**MODIFICATION REQUEST:
MP10_0016 MOD 2**

***Scottish Hospital Seniors Housing and
Care Facility***

Environmental Assessment Report
Section 75W of the *Environmental Planning and
Assessment Act 1979*

April 2017

Attachment D: Site Establishment - Stage 1 (PM-P-2002, Rev 3)

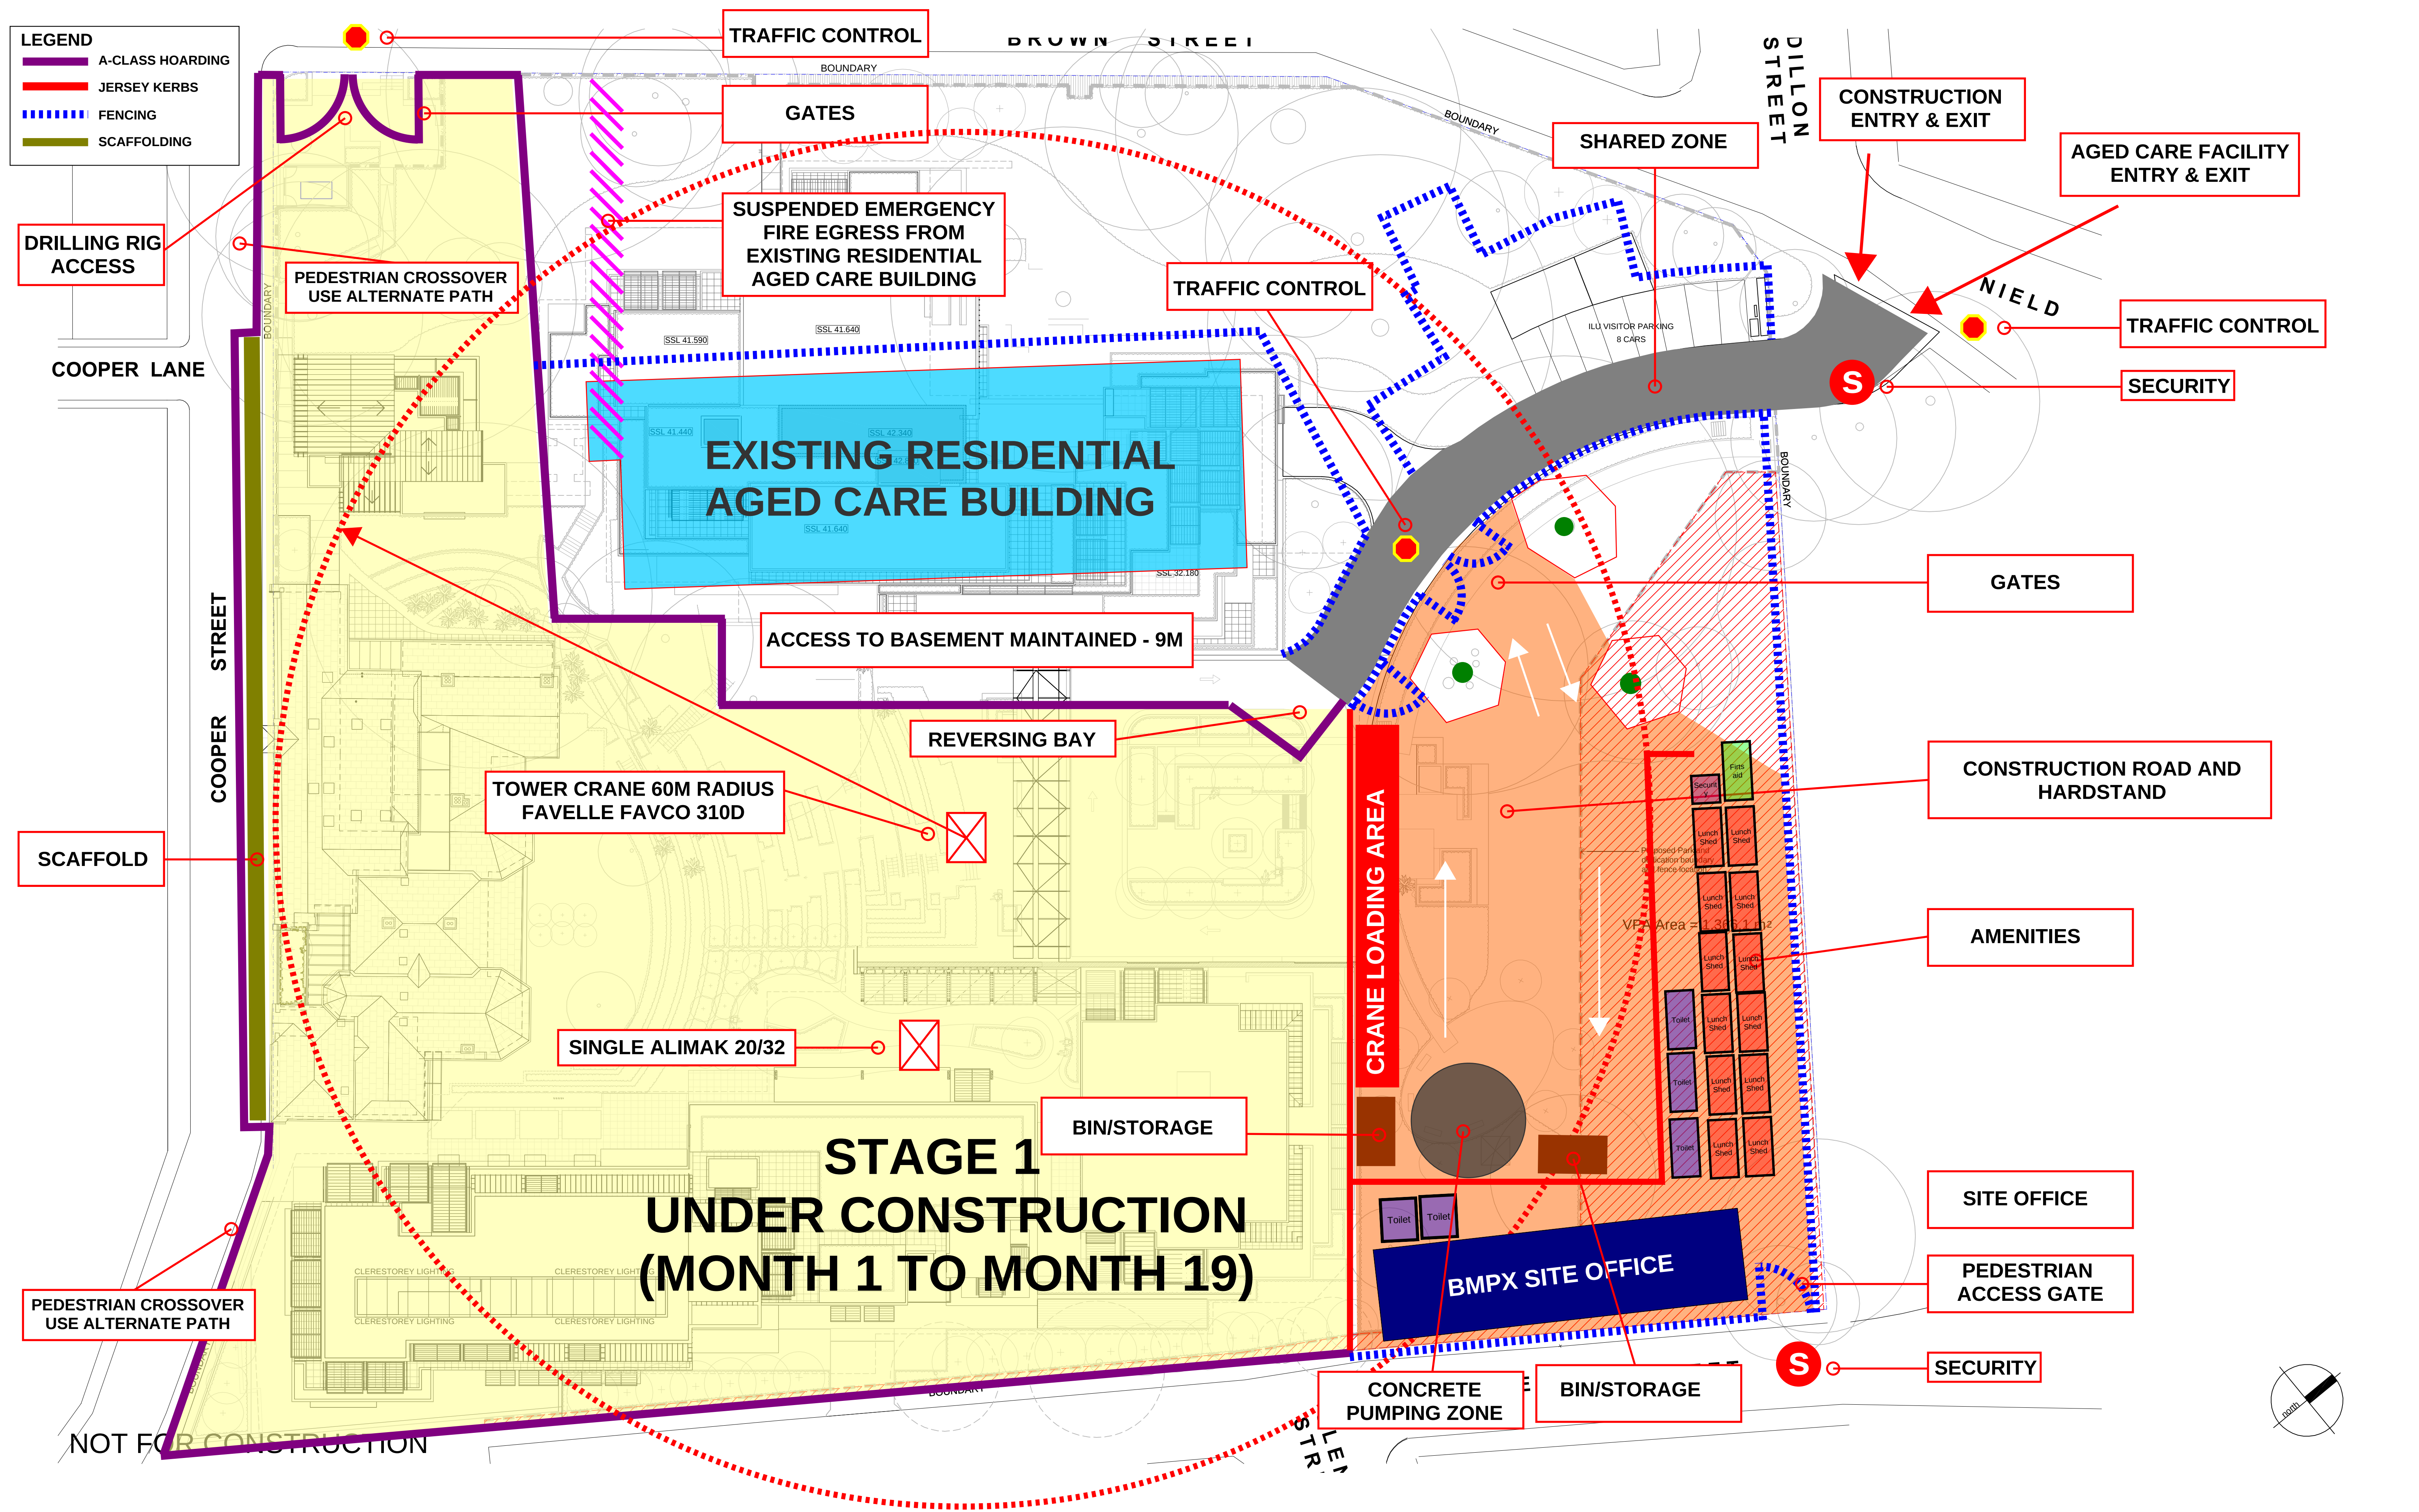
In response, the Proponent advised that in order to retain Tree 5, the access road for construction vehicles and Stage 1 of the development would bend around and between Trees 5 and 6 and that heavy vehicles would need to manoeuvre within 1-2 metres of Tree 127. This would not allow for tree protection fencing to be installed and would call into question the ability to retain Tree 127. The Proponent also explored an alternate location for access at Gate 5, however this was not suitable due to the significant level change between the street and the site in this location, the need to retain two trees and external traffic conflicts. The road alignment if Tree 5 is retained is shown in **Figure 4** and the road alignment if Tree 5 is removed is shown in **Figure 5**.

The Department considers the retention of Tree 5 creates an unviable and unsafe traffic environment during the Stage 2 construction works for the following reasons:

- the construction of the driveway around Trees 5 and 6 results in two hairpin turns and blind spots leading to safety risks; and
- trucks would be required to reverse on the access driveway, which provides access to Stage 1 of the development which will be in operation.

- Tree 127 – trucks would manoeuvre within 1-2 metres of Tree 127, which would not allow for adequate tree protection fencing around the tree to ensure its long term retention; and
- Tree 6 – trucks would manoeuvre within the tree protection zone (TPZ) of Tree 6.

The Department has reviewed the information provided and is satisfied the Proponent has demonstrated that it has explored reasonable options to maximise tree retention. Based on this information, the Department considers it acceptable to remove Tree 5 in order to achieve safe vehicular access for construction, and to minimise the impacts on neighbouring, more significant trees. The Department therefore supports the removal of Tree 5 and replacement with a 'super-advanced' Port Jackson Fig.

The Department recommends a condition of approval outlining the requirements for the replacement tree, specifically that Tree 5 is to be replaced with *Ficus rubiginosa* – Port Jackson Fig, and shall be 1,000 litres at the time of installation. The replacement tree is to be located within 10 metres of the current location of Tree 5.

**Option 3** | Infill Planting of *Waterhousia floribunda* and Transplanted Palms With Staged Removal of Selected Weed Trees

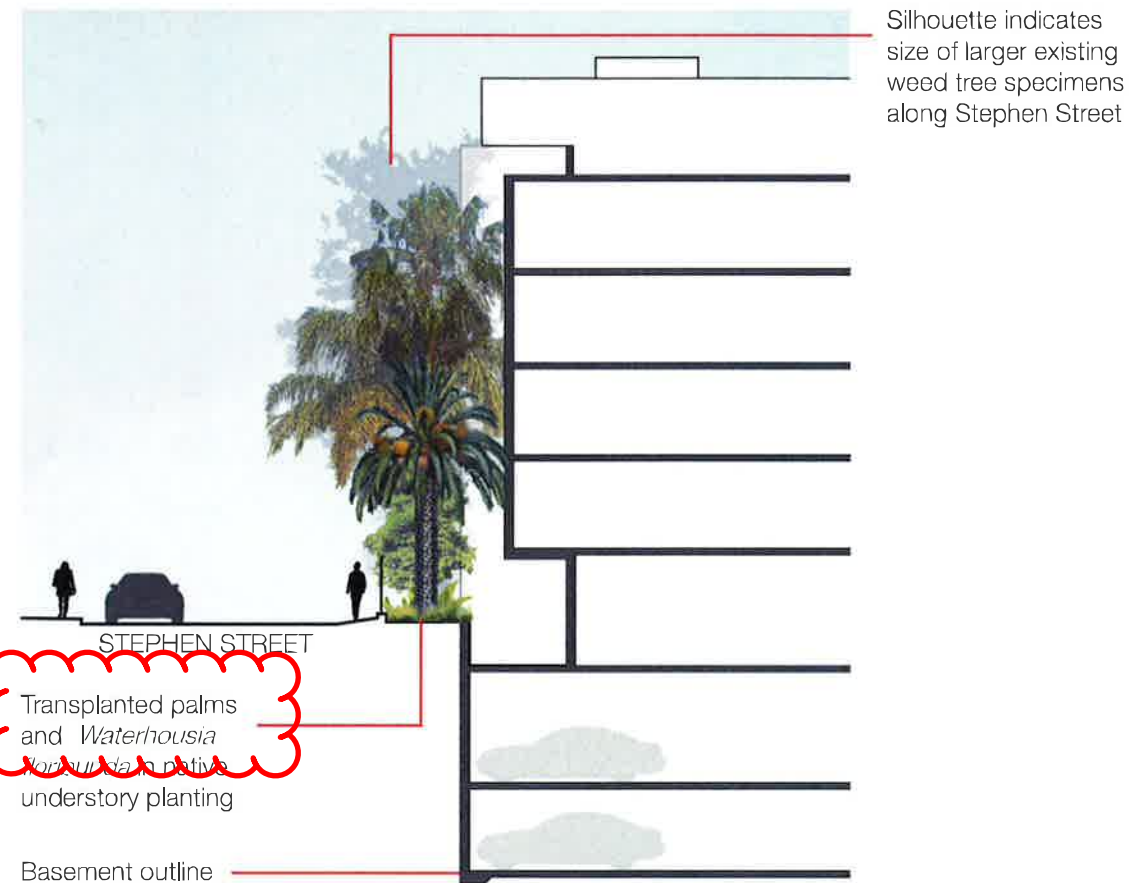
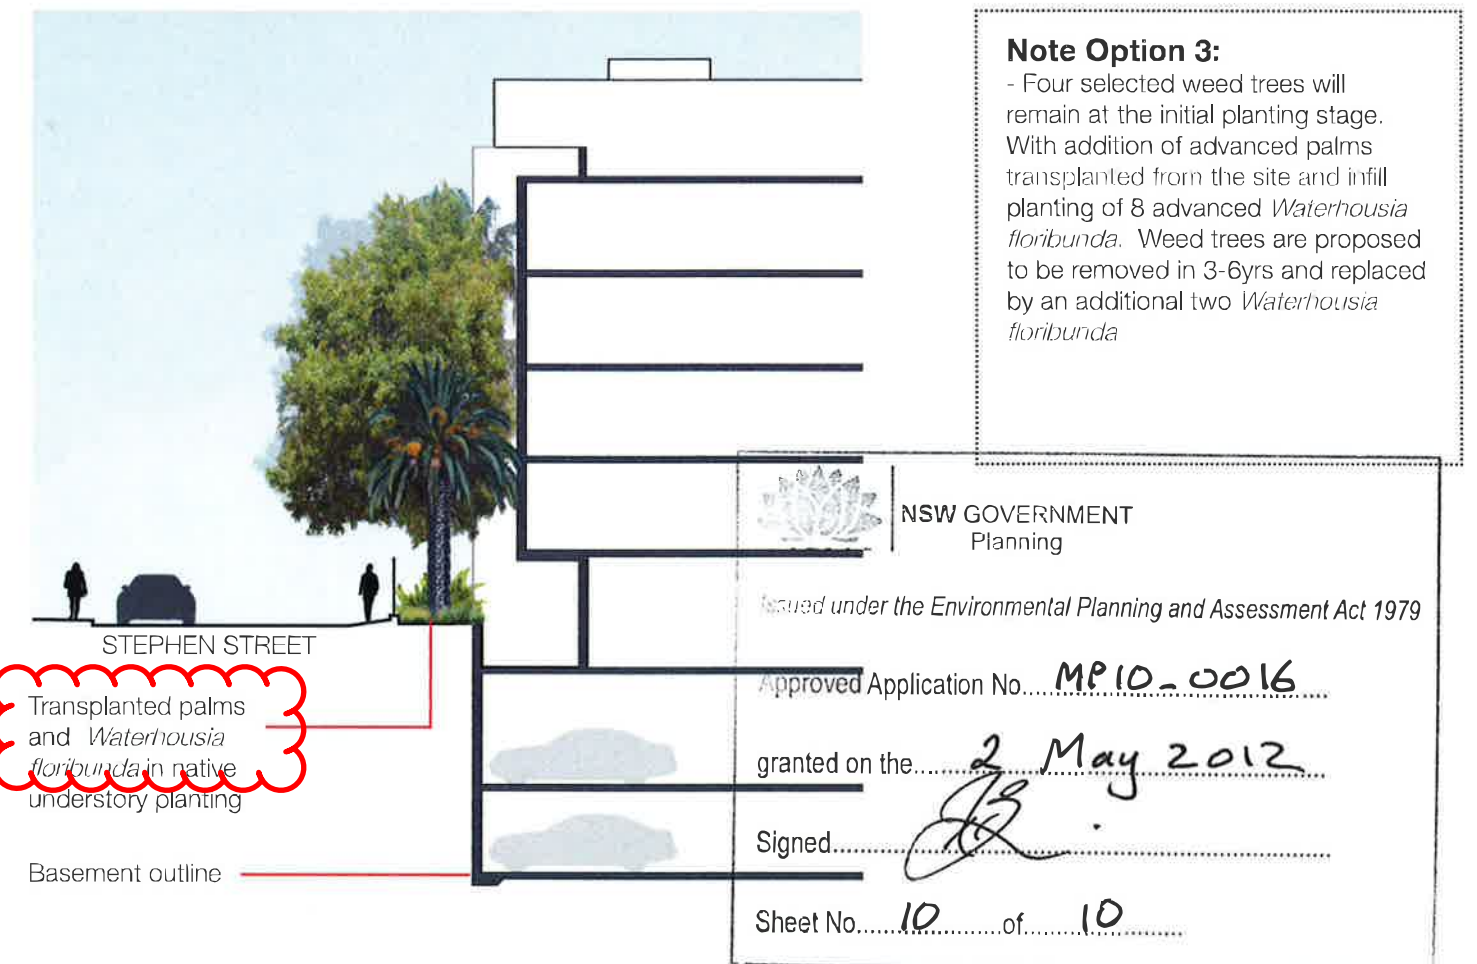
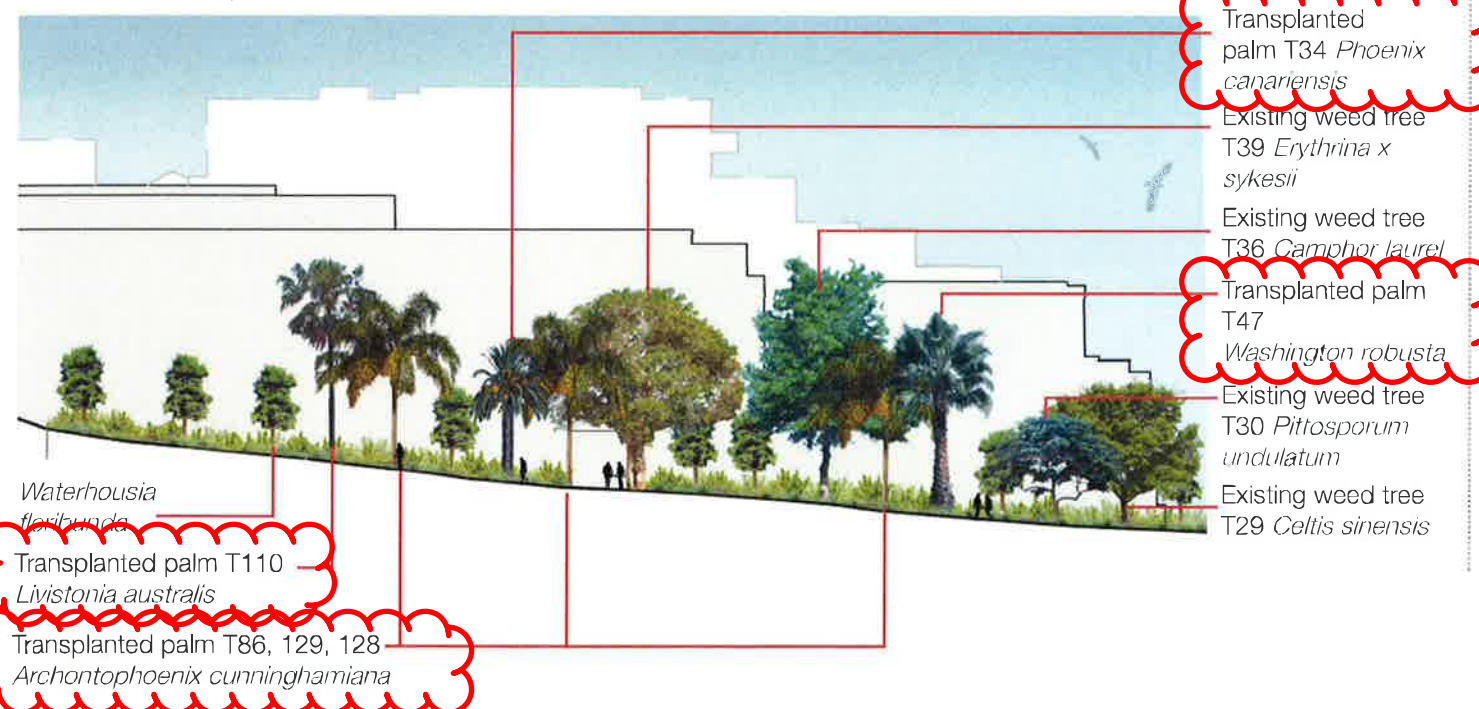
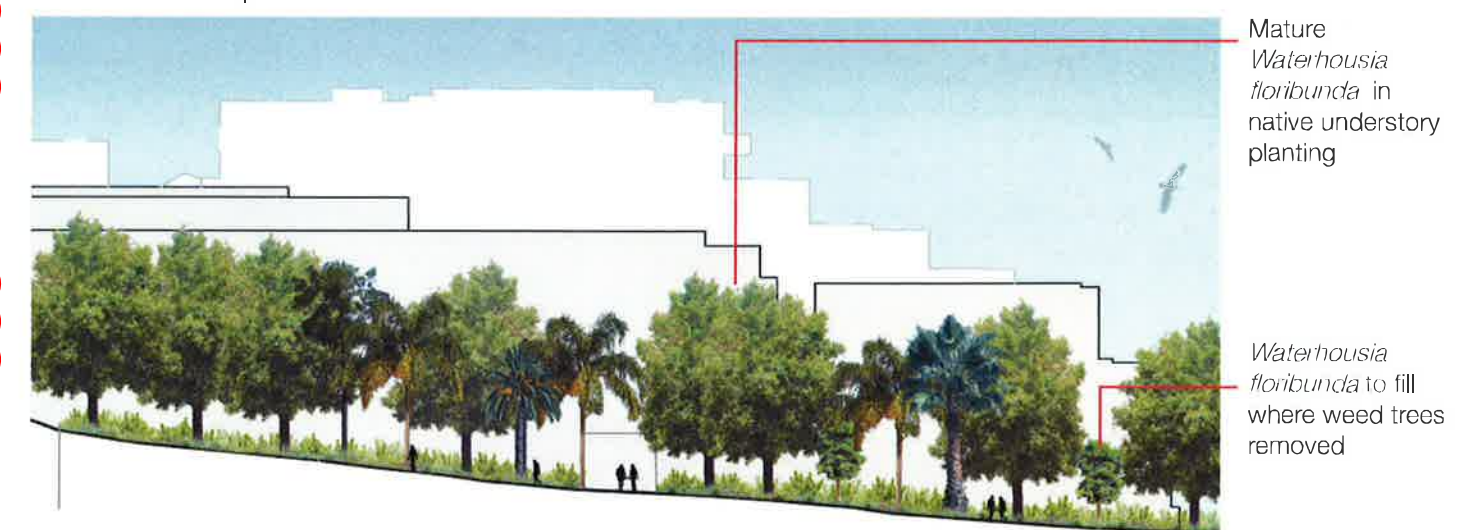
Public submissions raised concerns about the lack of arborist justification for not proceeding with the relocation of palm trees to Stephen Street, and expressed concern that having only Weeping Lilly Pilly would be visually monotonous. Submissions also noted that the relocation of the palms to elsewhere on site would change the landscape character in this area.

The Department notes the concerns raised in submissions about the visual impact of the planting on the Stephen Street frontage, and the desire by residents to retain as much as possible of the original gardens.

The Department notes the Proponent's view that the palms are not suitable for replanting where originally intended due to their advanced size and subsequent potential impact on underground services. The Department also acknowledges the review undertaken by Council that some of the existing palms may be relocated further north on Stephen Street without impacting services. The Department therefore supports the proposal by the Proponent to plant intermittent nursery sourced palms and Weeping Lilly Pilly along Stephen Street.

The Department also notes that the retention values of the five palm trees vary (1 Retention Value 'A', 3 Retention Value 'B' and 1 Retention Value 'C'), and therefore considers that all palm trees should be retained / transplanted within the site where there is sufficient soil area to accommodate the root balls, including further north on Stephen Street. The Department considers that as the Proponent is relocating existing plants within the site, the landscape character of the area is being retained. Condition of approval C4(iii) has therefore been amended to reflect this requirement.
